Lawful Development Certificate for a Proposed Use or Development

Development: Proposed loft conversion
Location: 111 Oakcroft Gardens Littlehampton BN17 6LU

Existing and Proposed Plans

Drawing Number	2026/138	Sheet	2 of 2
Size	A1	Scale	1:50, 1:100, 1:500, 1:1250

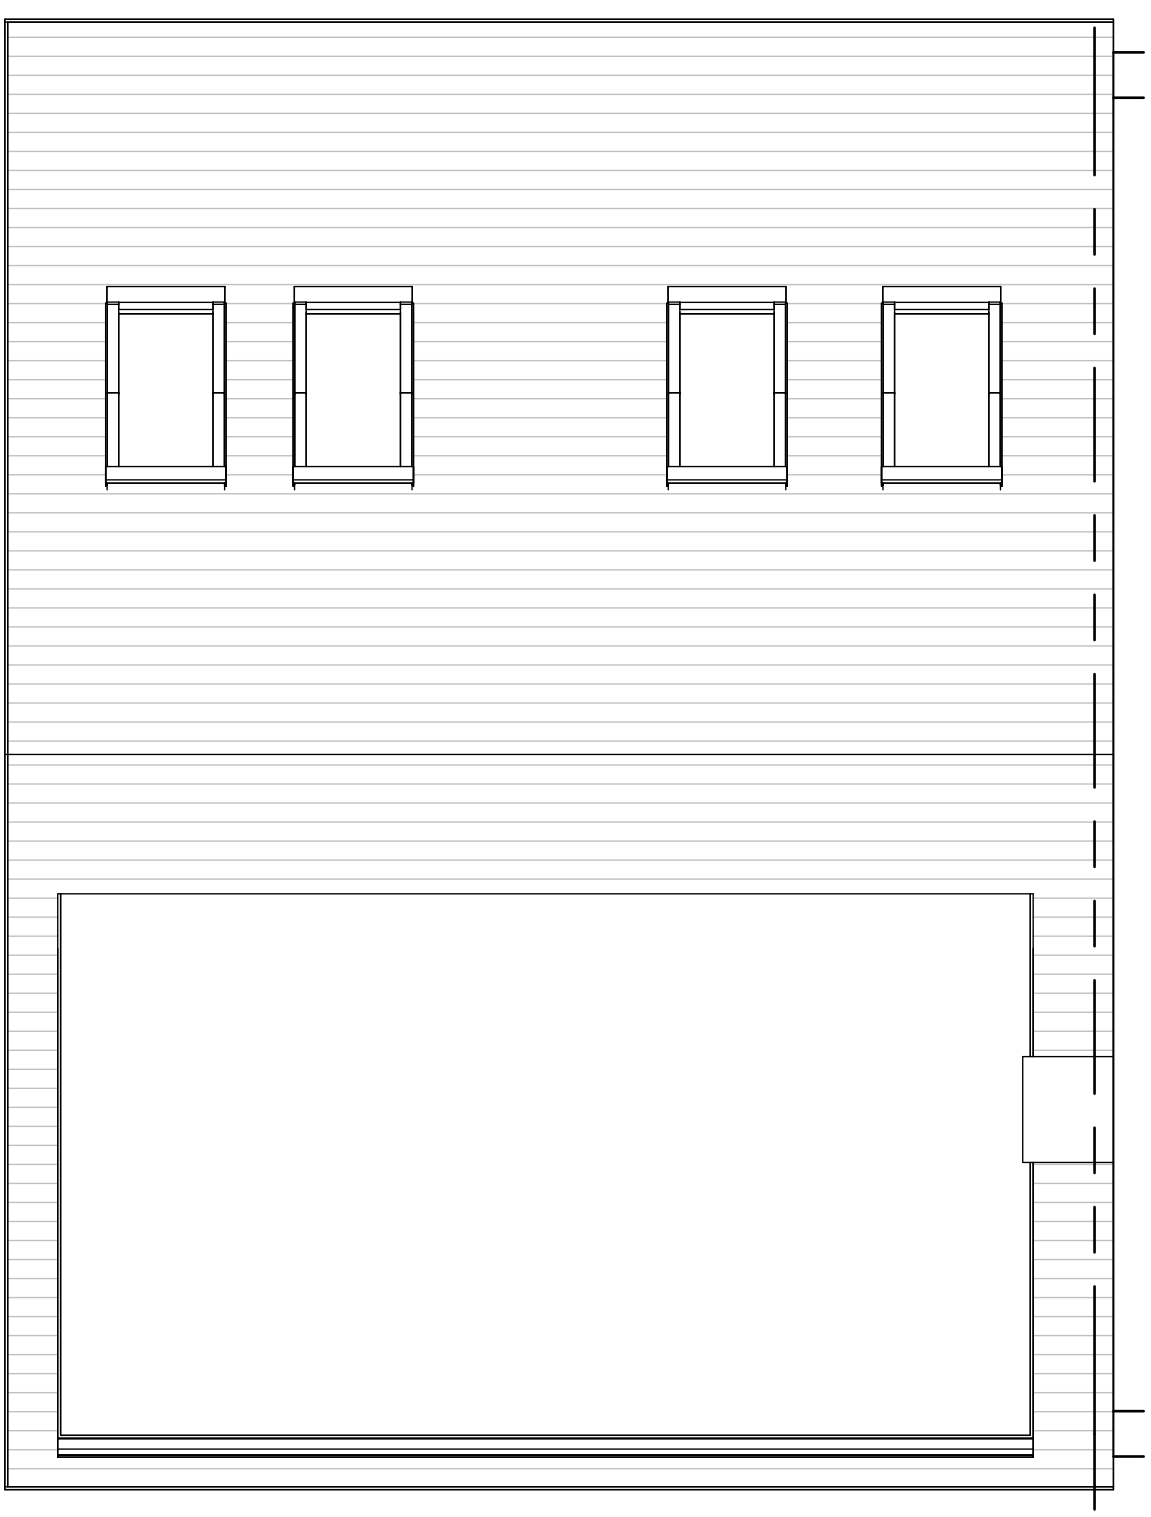
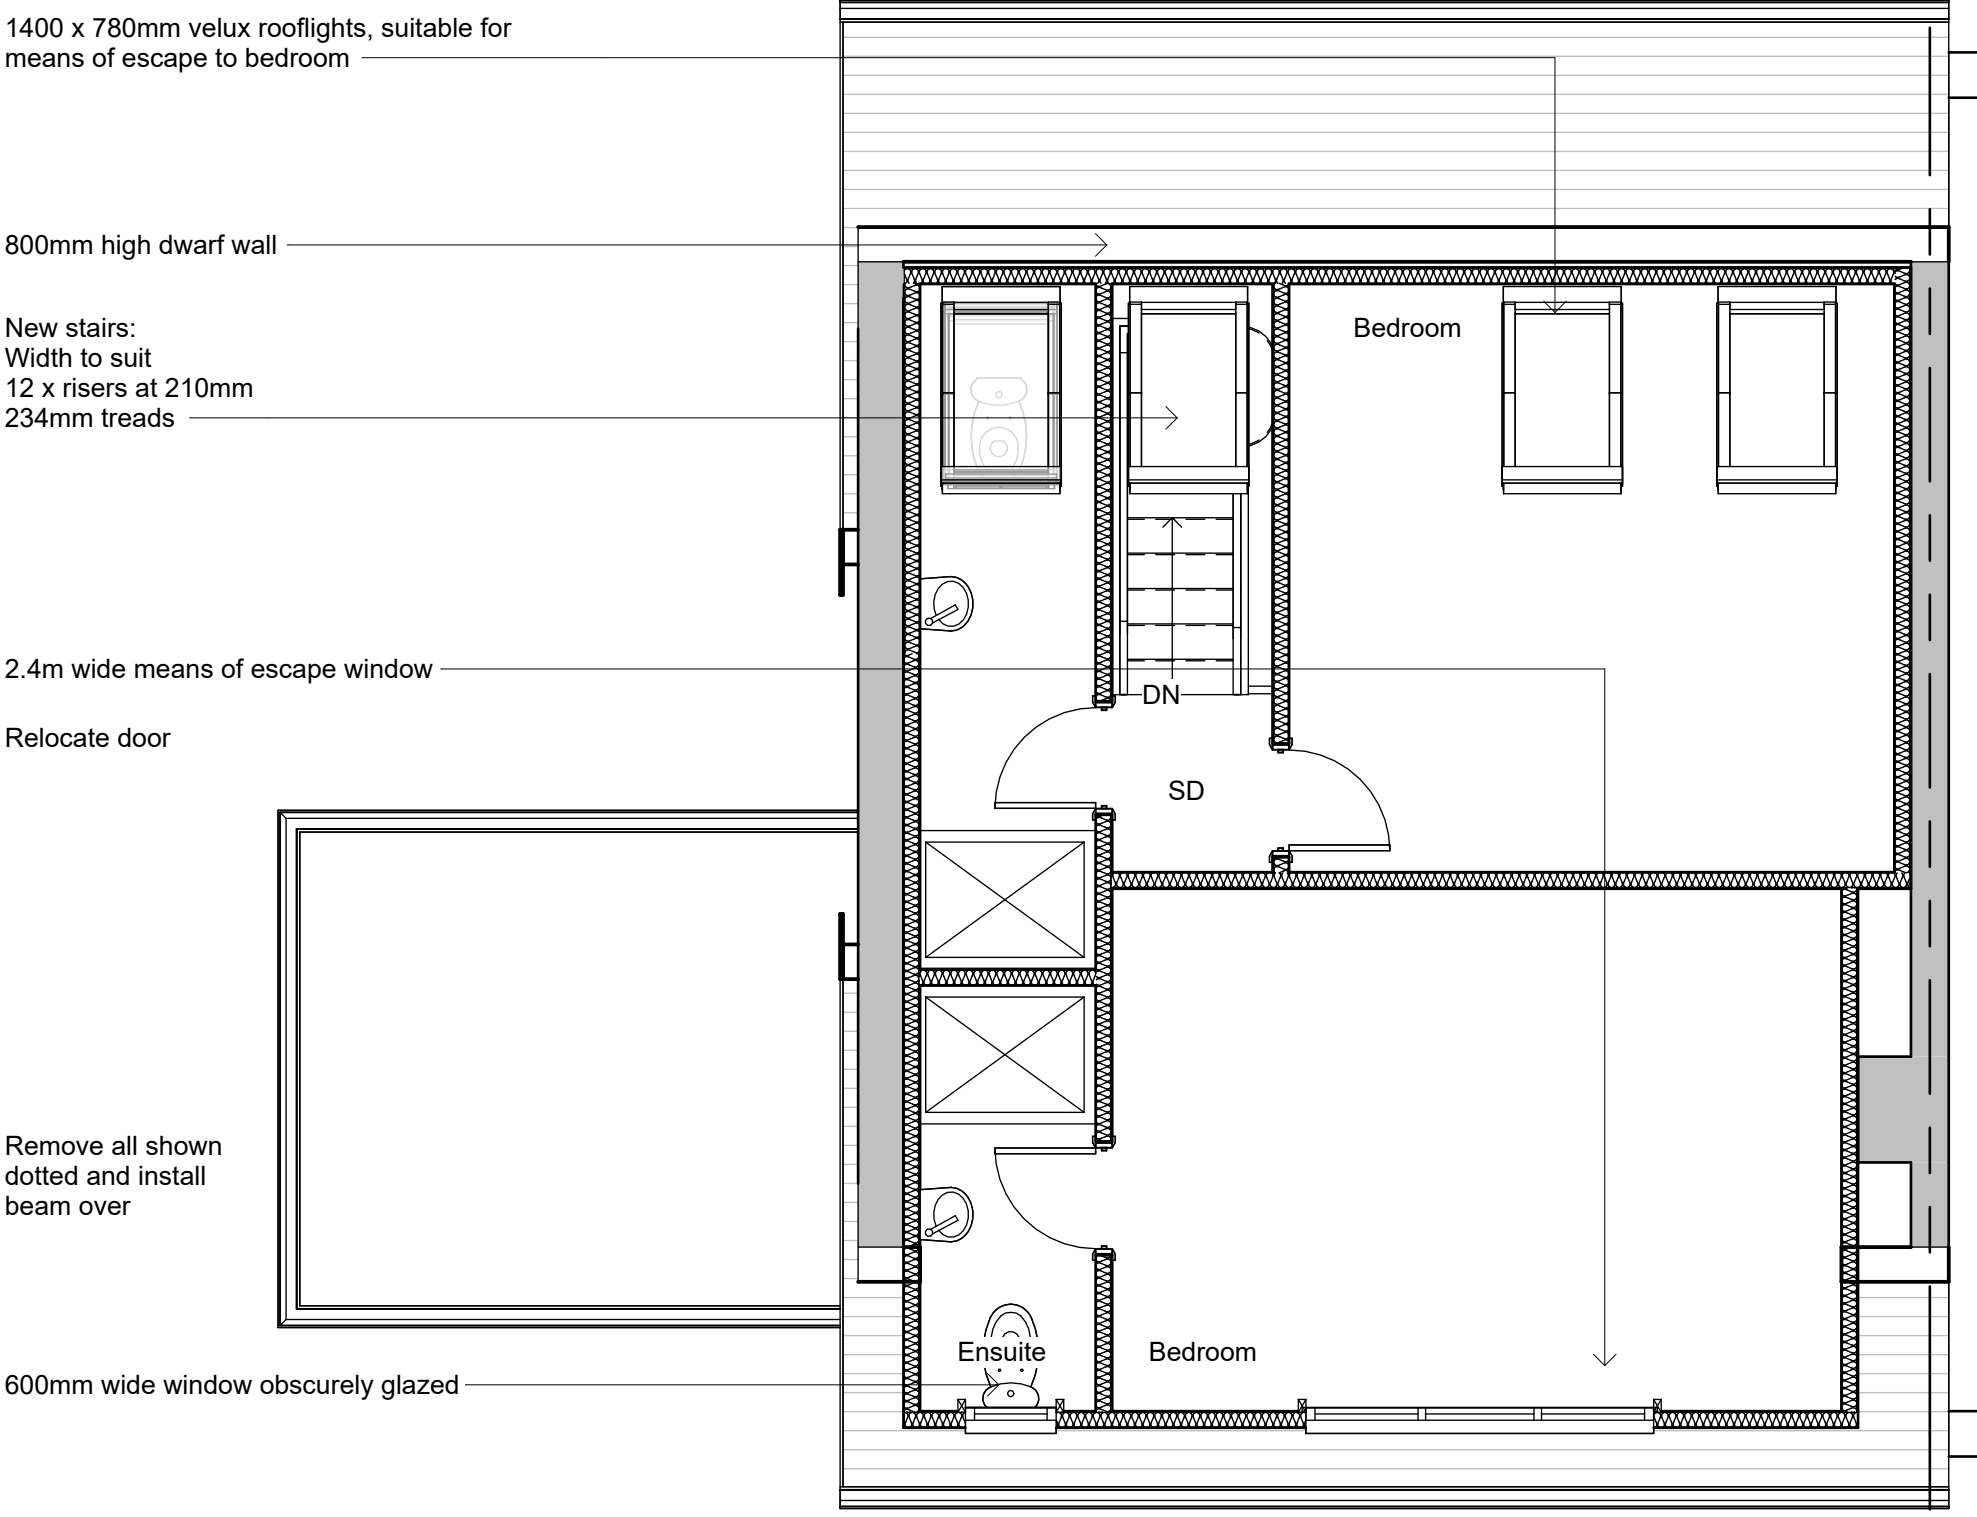
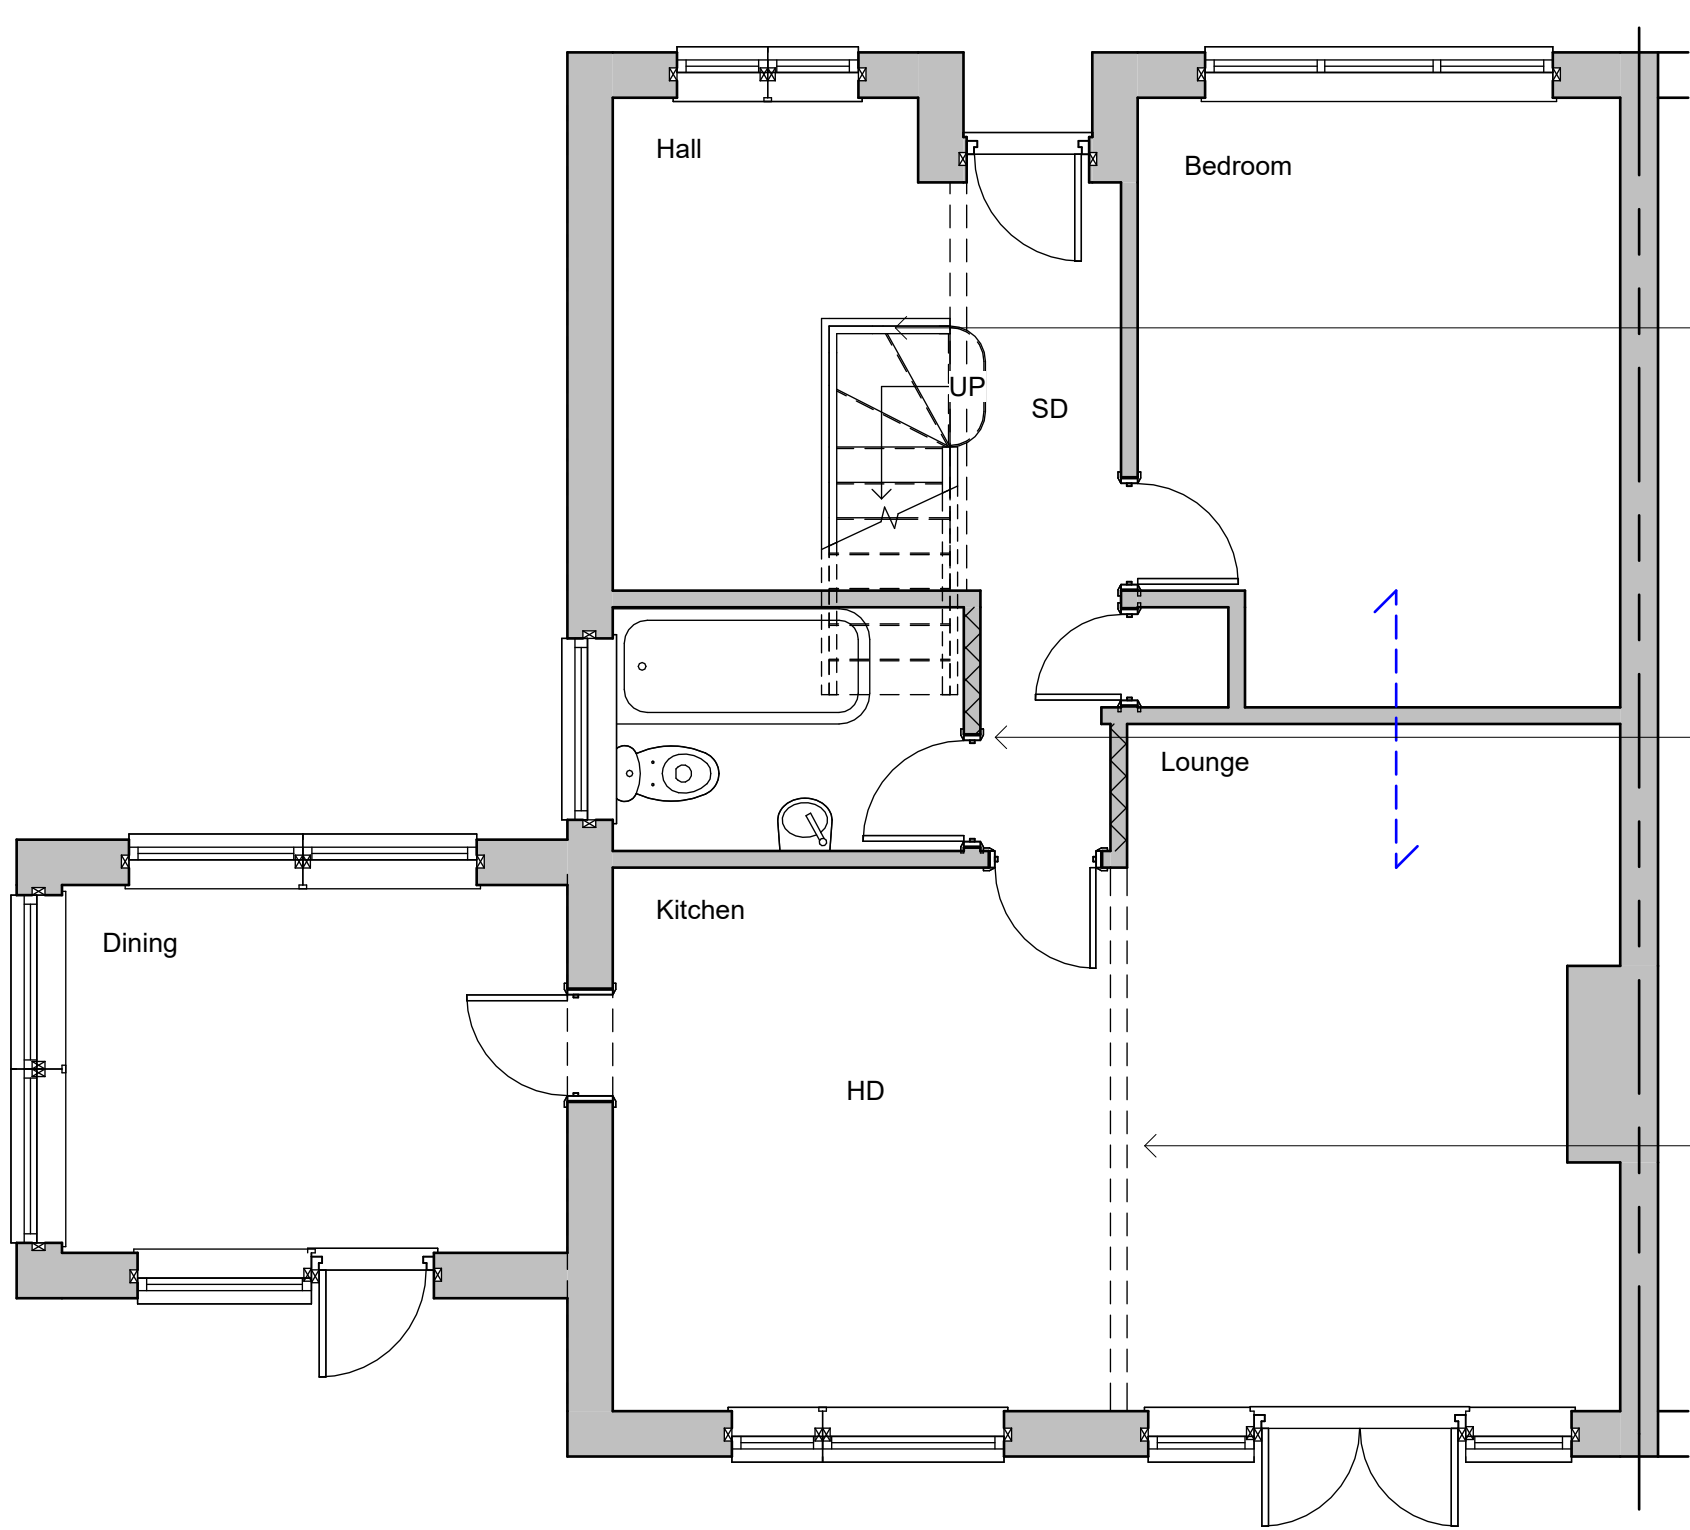
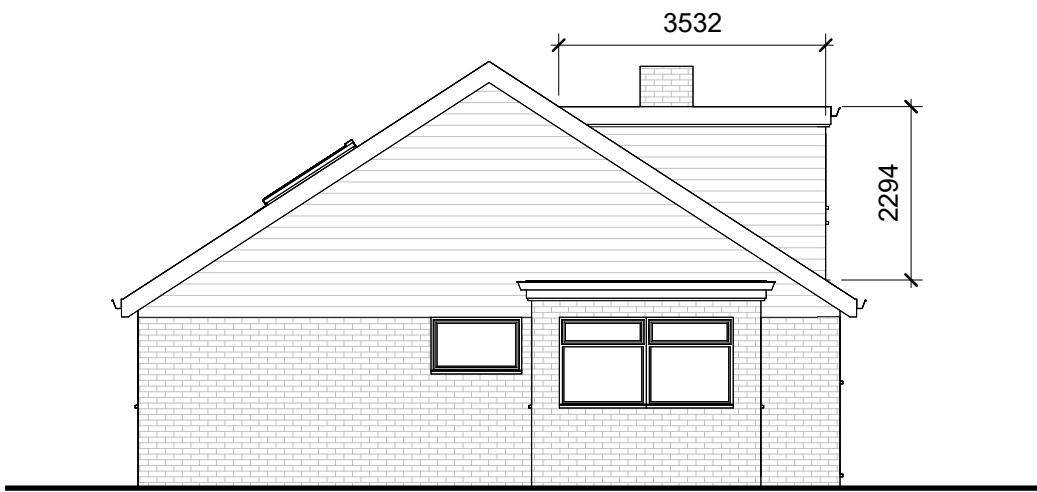
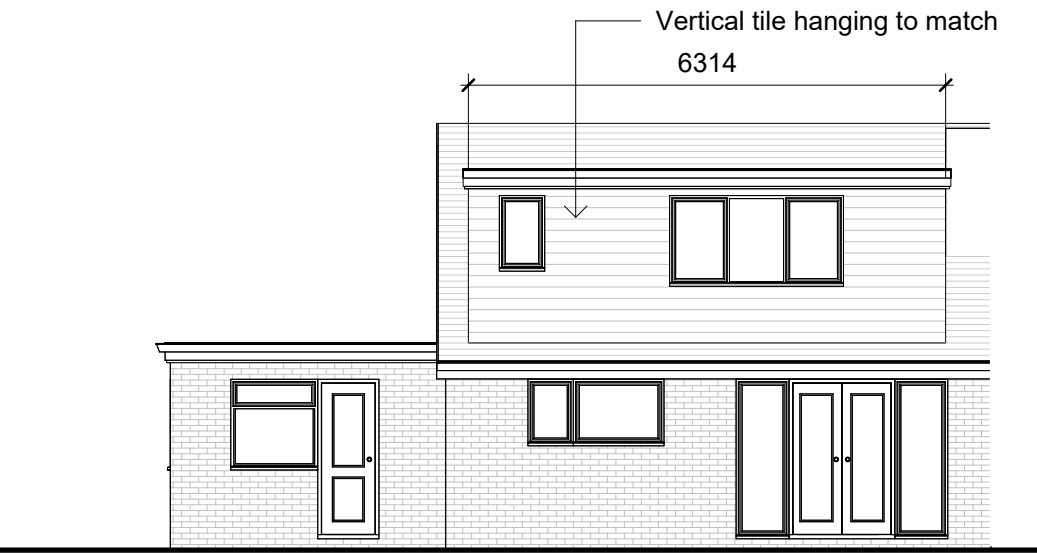
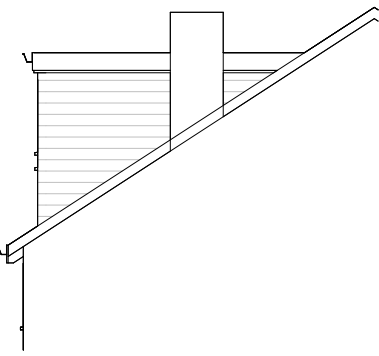
Please add labels to your elevations, floor plans and roof plans to indicate which scale they are.
